CEMEX

COMMENTS ON EXA'S FIRST WRITTEN QUESTIONS

HIGHWAYS ENGLAND'S RESPONSE

1. EXAMINING AUTHORITY'S WRITTEN QUESTIONS AND REQUESTS FOR INFORMATION M4 JUNCTIONS 3 TO 12 SMART MOTORWAY

Drawing Title
WIDENING WORKS AND FLOOD MAPS CROSS SECTION DRAWING SITE REF: RIDING COURT ROAD

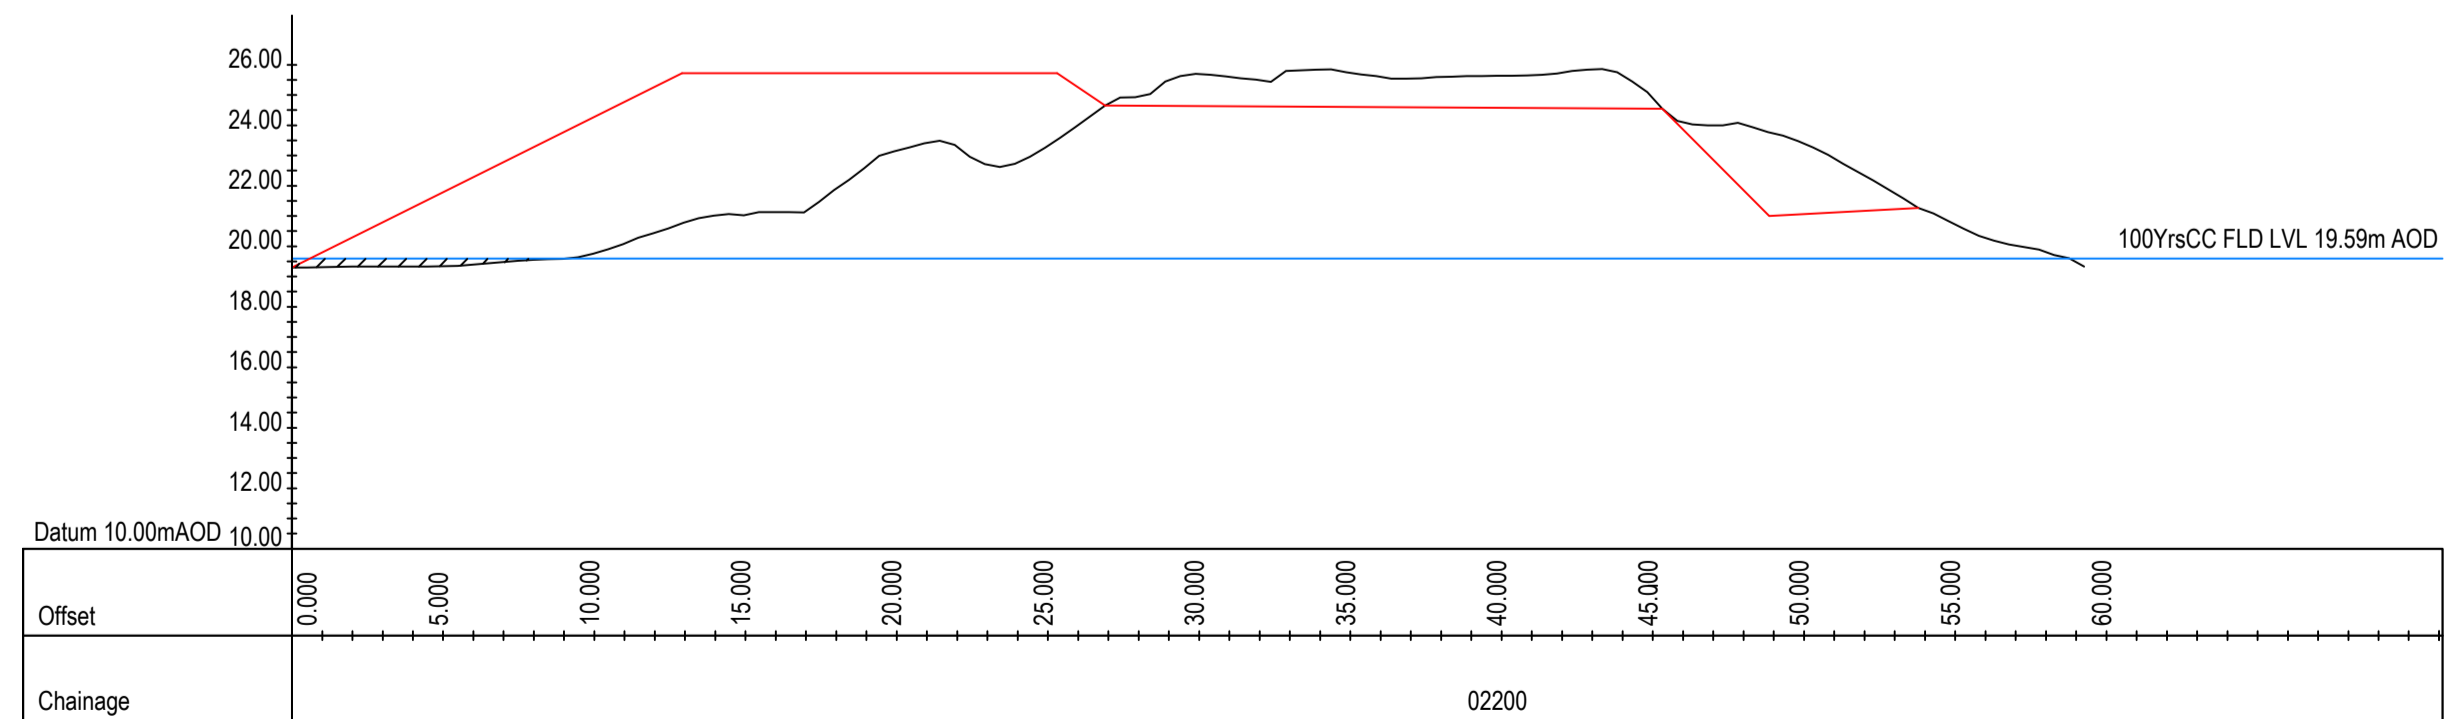
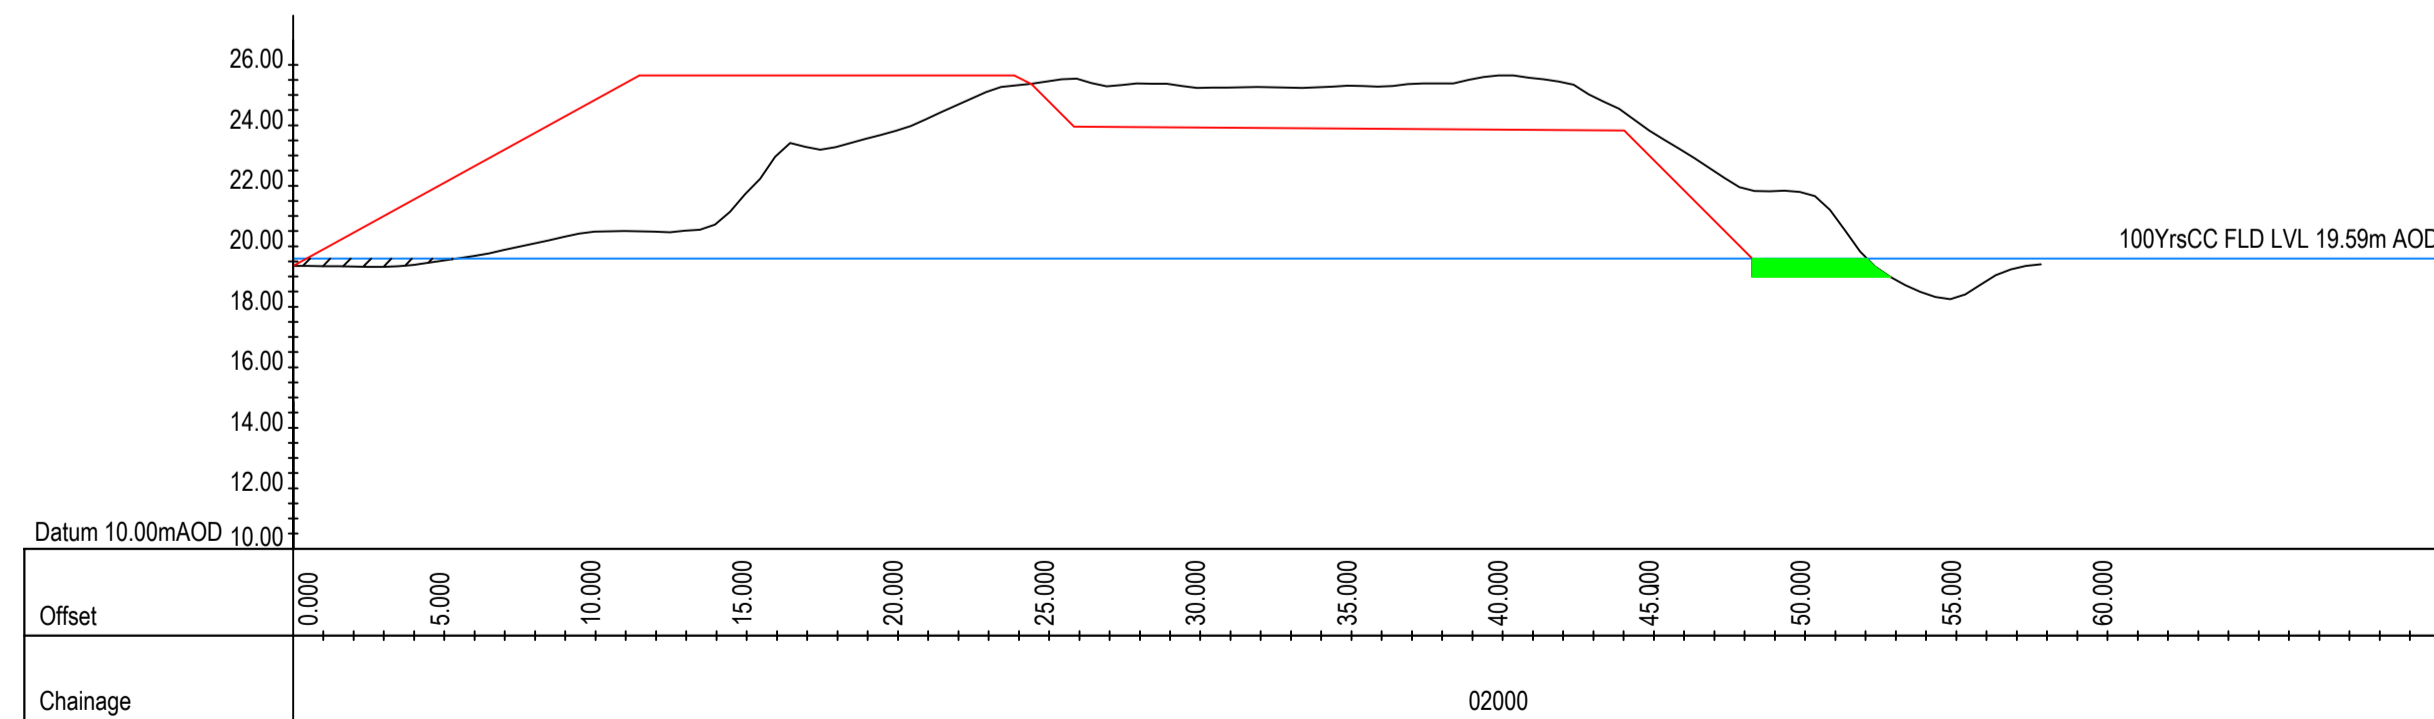
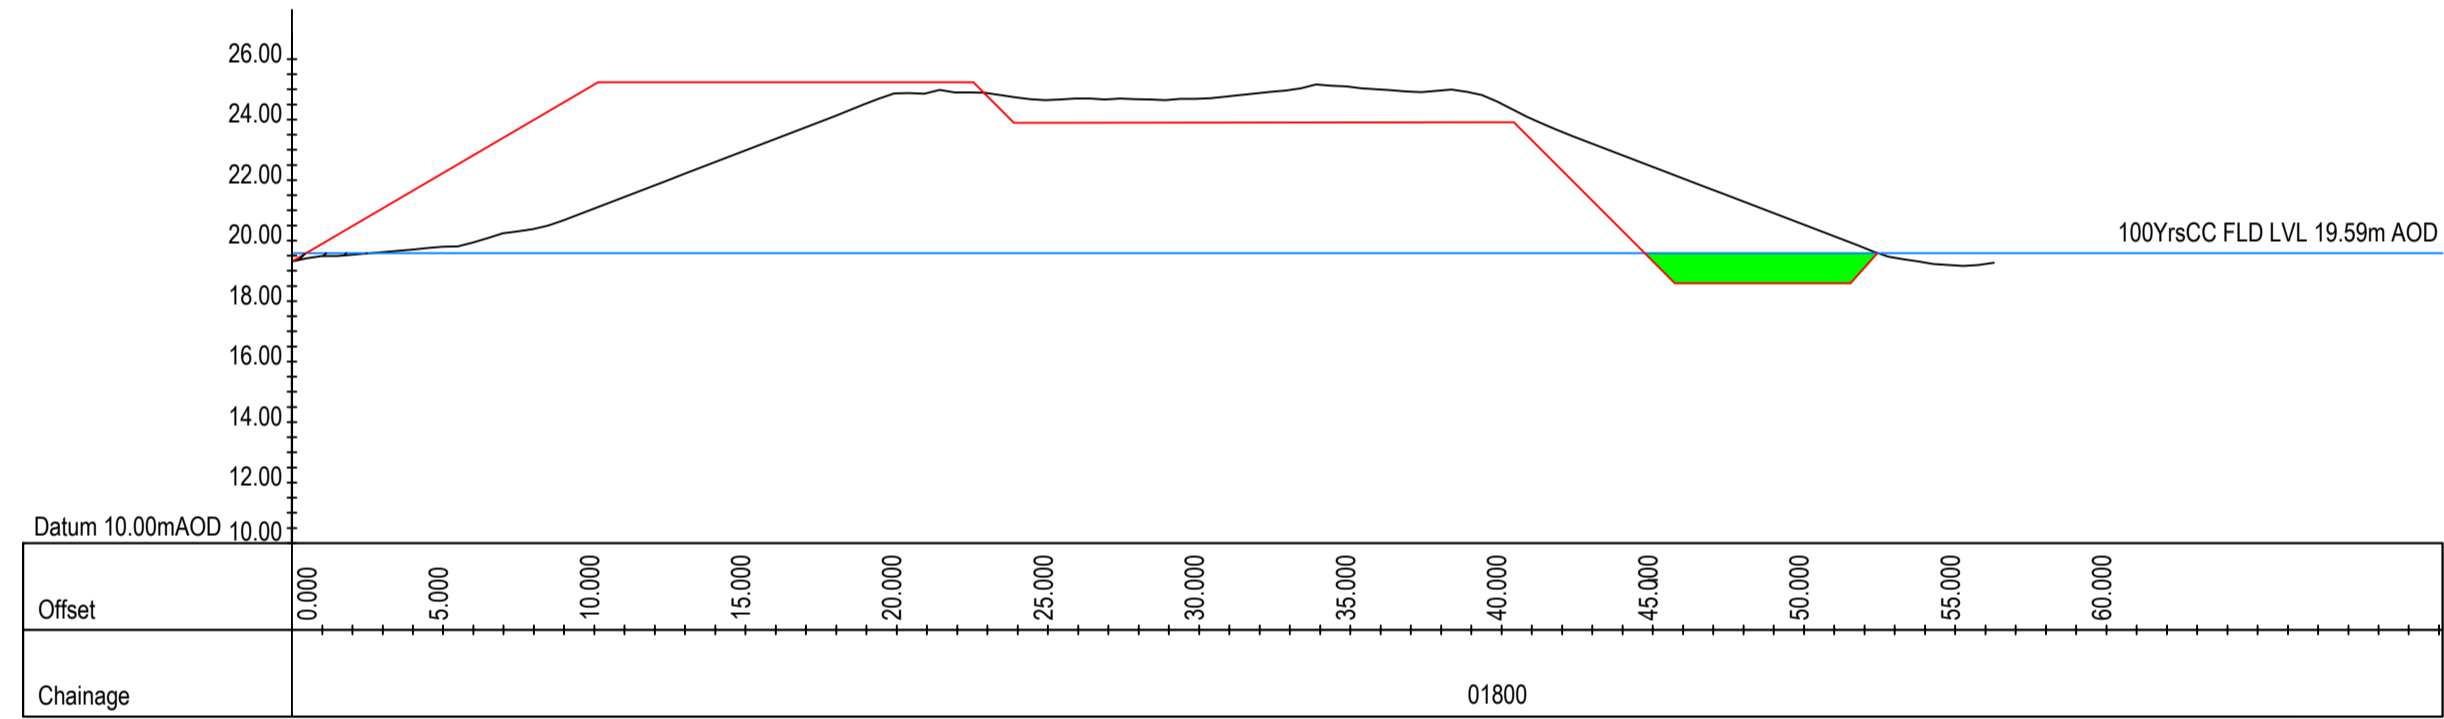
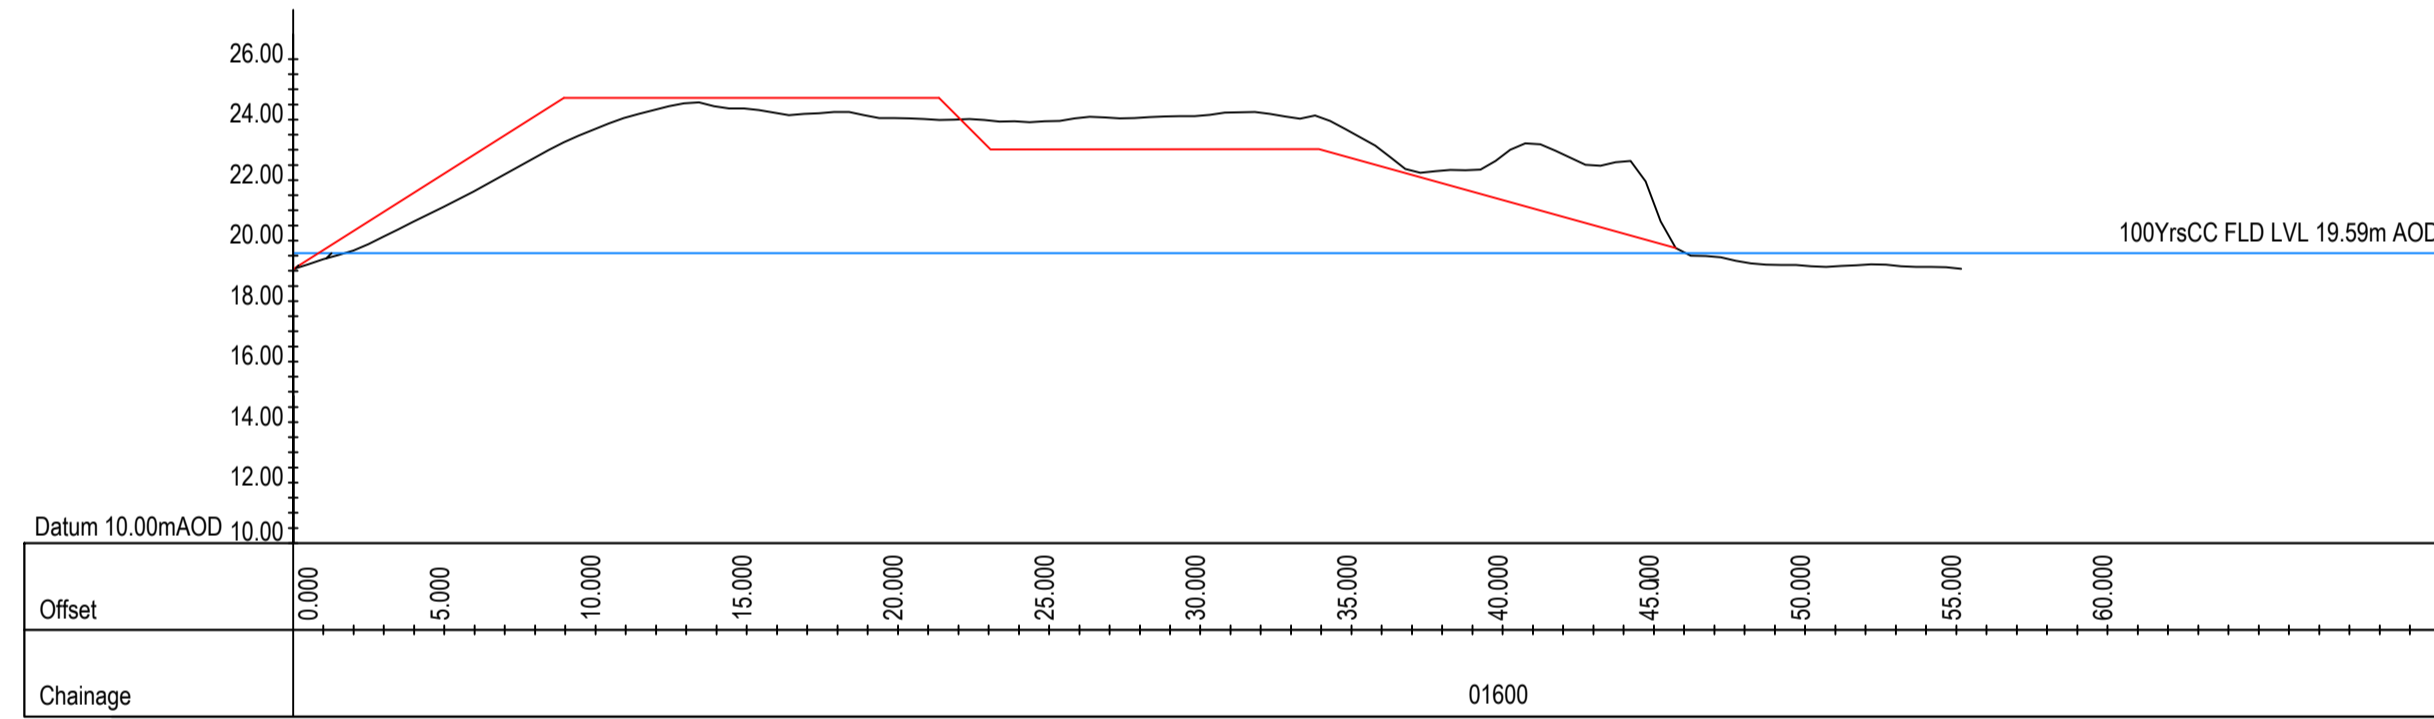
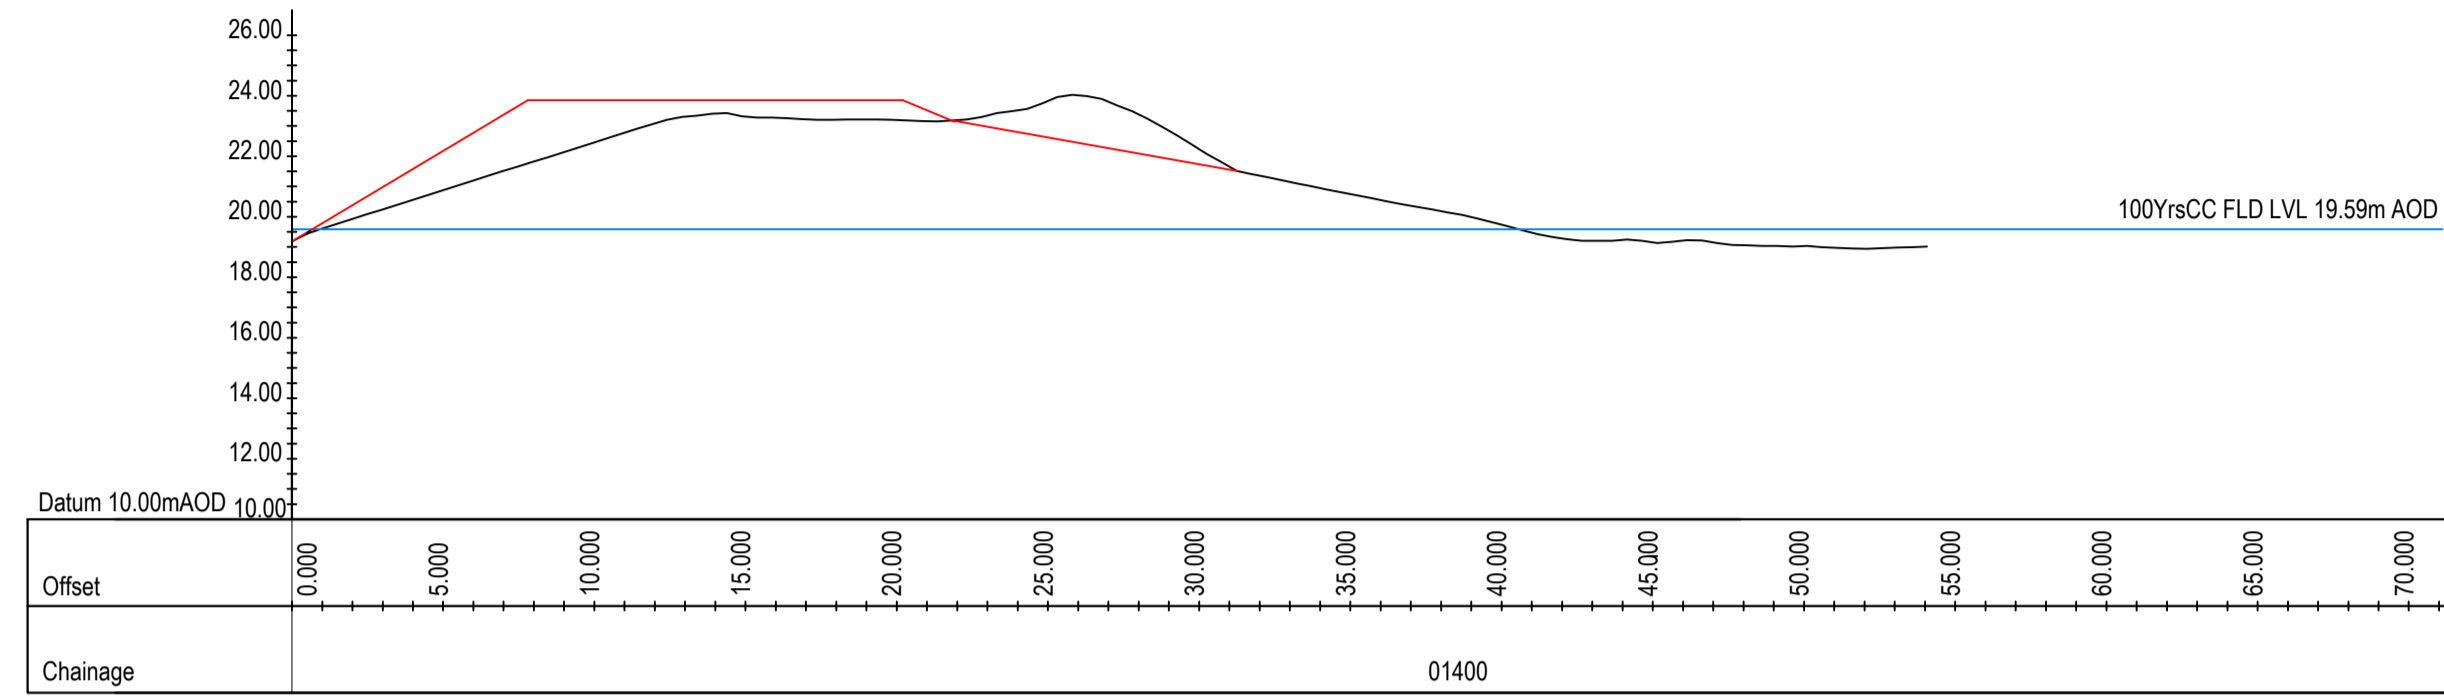
1.5 *It is understood by CEMEX that the DCO application by Highways England is to reconstruct the Riding Court Road bridge over the M4 offline, which should ensure less disruption to traffic flows along Riding Court Road. CEMEX UK Operations Ltd is supportive of this offline construction. Lands Plans Sheet 24-31 Drawing TR010019 -2. indicates this offline construction.*

1.7 *The plans show that in terms of the extraction area there is no overlap between the two schemes, but the red line for the Order Limit - Work No 22a does enter the application site and coincide with land where CEMEX would have tree protection and soil storage and amenity protection bunding. The Order Limit for Highways England's application also covers Riding Court Road, CEMEX's access onto Riding Court Road, the James Meadow Roundabout and the lower end of Ditton Road. At this stage from Highways England's application documents and EIA it is unclear why this land is included within the M4 scheme*

1.5.1 Highways England confirms that the proposed works at Riding Court Road overbridge are to provide an offline replacement structure to the north-west side of the existing bridge. This will enable access across the M4 to be maintained throughout the construction period.

1.7.1 Highways England has reviewed the drawings which CEMEX has provided in response to the Examining Authority's first written questions (Question 9.24) and note that there are three areas where the Order Limits for the Scheme coincide with the site of PP13/01667.
